PLANNING CONSULTATION RESPONSE

Application No	2025/1088
Proposal	2 Storey side extension and single storey front extension to dwelling
Address	8 Market Square, Goldthorpe Barnsley S63 HD
Date of Consultation Reply	06/02/26
Consultee	Highways Development Control

Proposed Block Plan 1:500

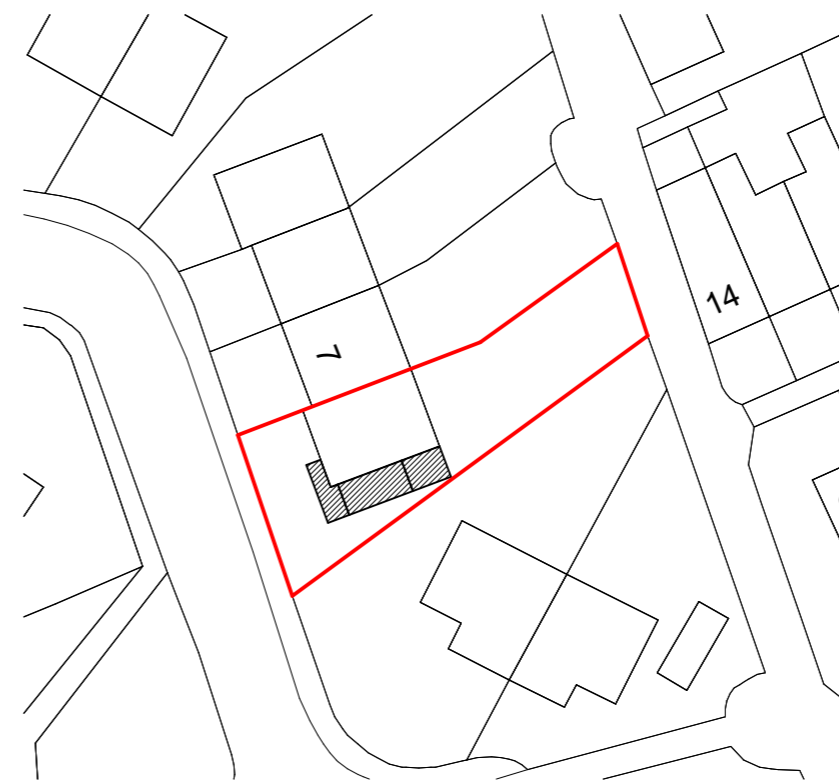
Having reviewed the submitted plans, the proposed garage measures only 5.5m x 2.3m internally, which is below the 6m x 3m internal dimensions required for a space to be recognised as a parking space. In addition, the proposed extension reduces the driveway length to around 3m, which is not sufficient to accommodate an off-street parking space. The scheme therefore results in the loss of existing off-street parking provision in an area where demand for on-street parking is high.

Proposed Ground Floor Plan 1:100

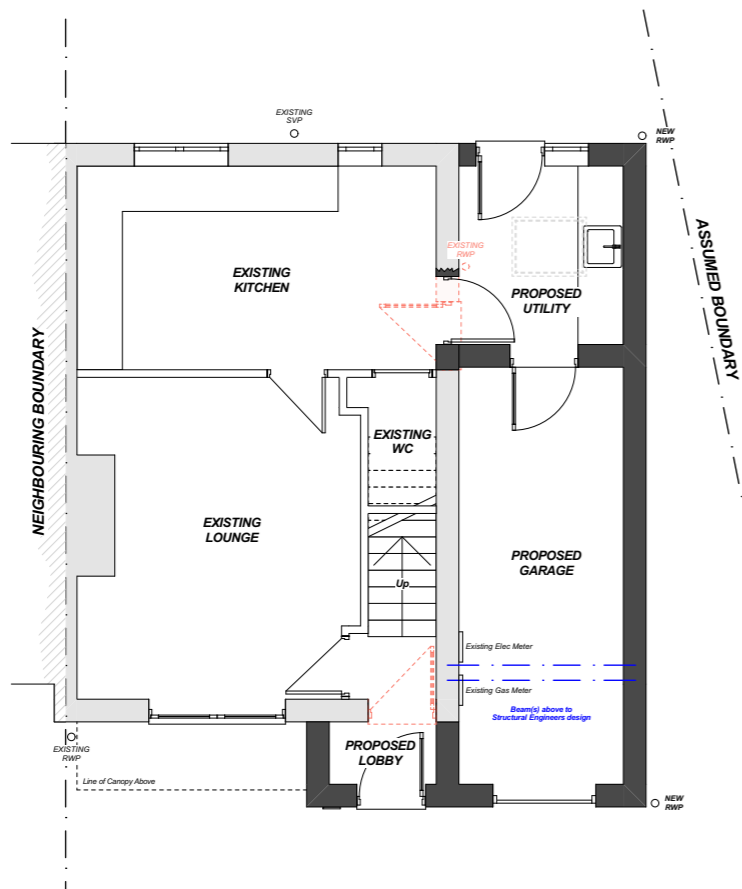
Given the existing parking pressures in the area, the loss of a usable parking space is not acceptable and as such, Highways Development Control must object to the application.
